URBAN DESIGN COMMENTS

Site Address: Union Park UP4, North Hyde Gardens
Planning ref: 75111/APP/2025/739
Case Officer: Michael Briginshaw
Design Officer: Todor Kuznetsov
Date of comments: 28.04.2025
Proposal: Redevelopment of site to deliver extension to existing Union Park data centre campus consisting of (a) free standing data centre building (b) energy, power, and water infrastructure (c) site access and internal roads (d) site security arrangements (e) hard and soft, green landscaping and (f) other ancillary and auxiliary forms of development

**A90 - EXTERNAL WORKS
B4 Enlarged Site Plan**

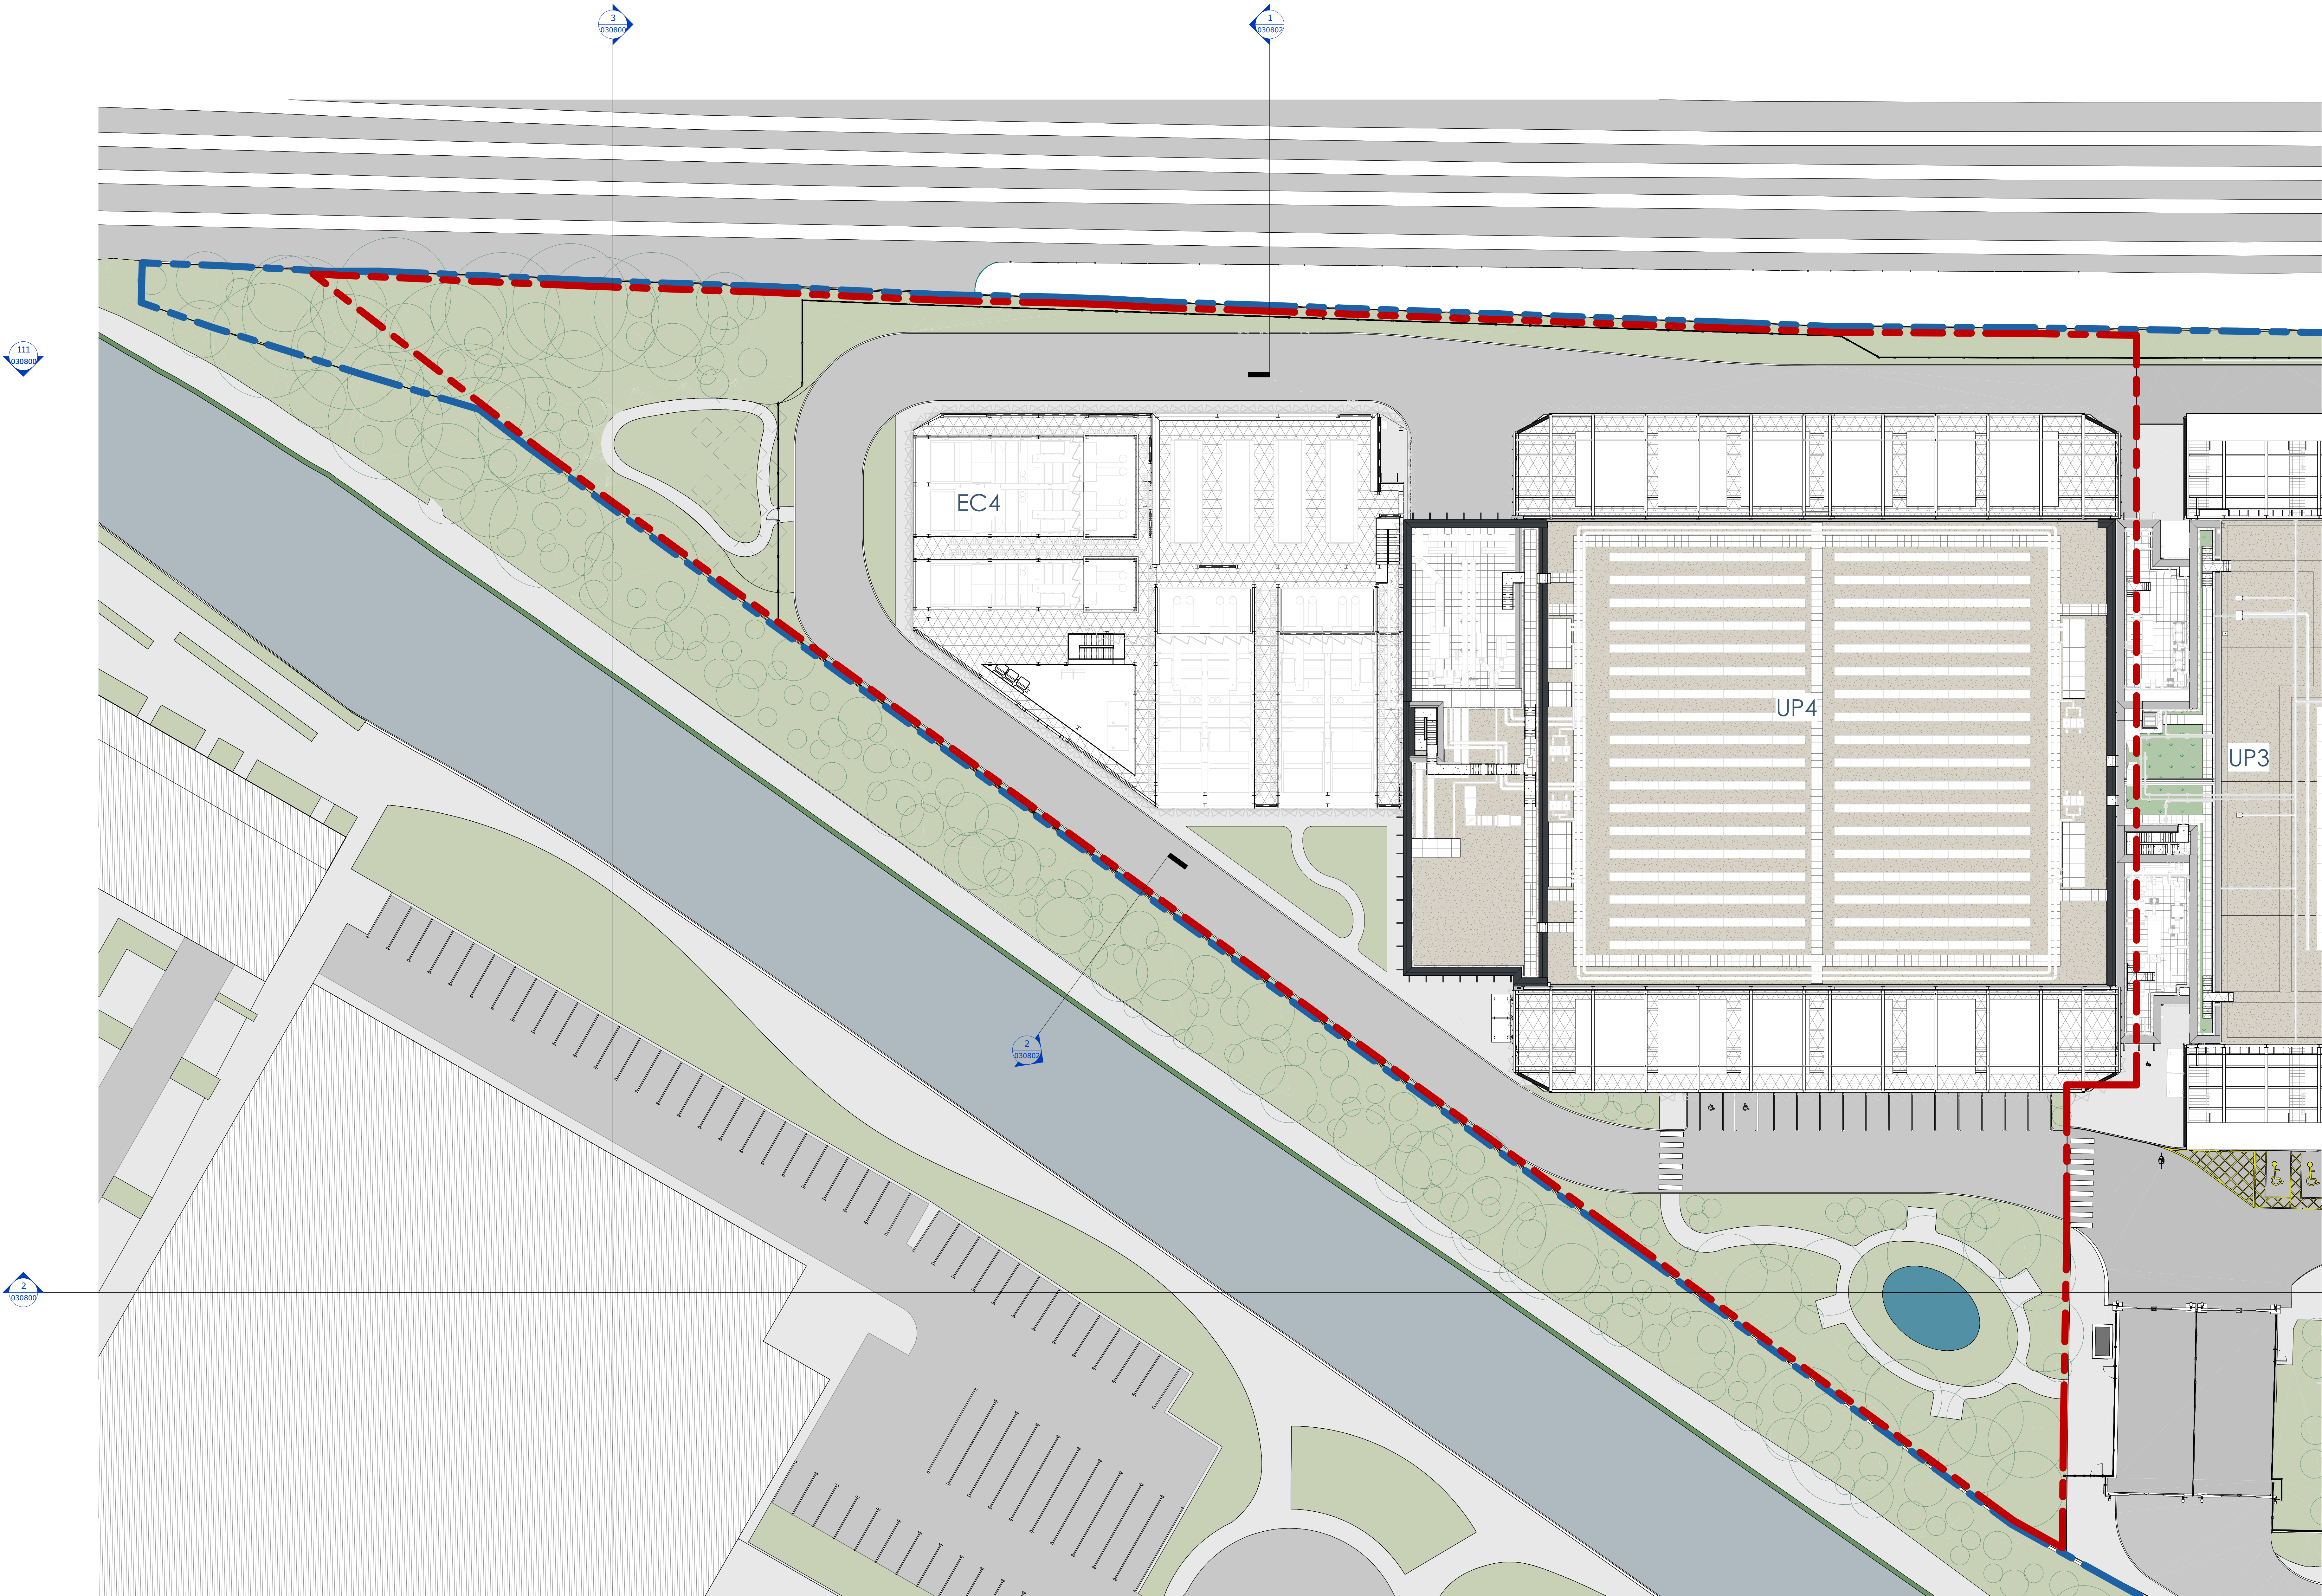
It is also highly recommended that all elements of the proposed fence facing the canal-side utilises green colour to blend it with the existing green buffer and avoid drawing undue attention.

The relationship between the proposed landscaping and underground utilities remains outstanding. While this issue was raised during the pre-application process, it has not yet been conclusively addressed. It is essential to ensure that underground services do not impede the delivery or long-term success of the proposed greening strategy. In particular, confirmation is required - ideally through a coordinated services plan and supporting sections, or alternatively via annotations on provided plans - that utilities are not routed through landscaped areas in a way that would compromise the proposed planting, and that sufficient soil depth and quality will be provided to support the healthy establishment of trees and other vegetation as proposed.

The term “species rich reinforced grass for heavy vehicular turning” is unclear and requires further clarification. It is unclear how landscaping which is meant for heavy vehicular turning can also be species rich and reinforced grass at the same time. We’d like to understand the product / system for this in principle before detailed condition discharge.

While we acknowledge that the proposed data centre use requires a specific level of security, driven by end-user requirements and guidance for nationally significant infrastructure projects, we would welcome further justification for the use of Concertina Razorwire and clarification as to why less utilitarian [alternatives](#) - such as outward cranked toppings, bulldog spikes / croctop / security spikes or similar, or at the very least a simpler outward cranked barbwire solution - are not considered suitable.
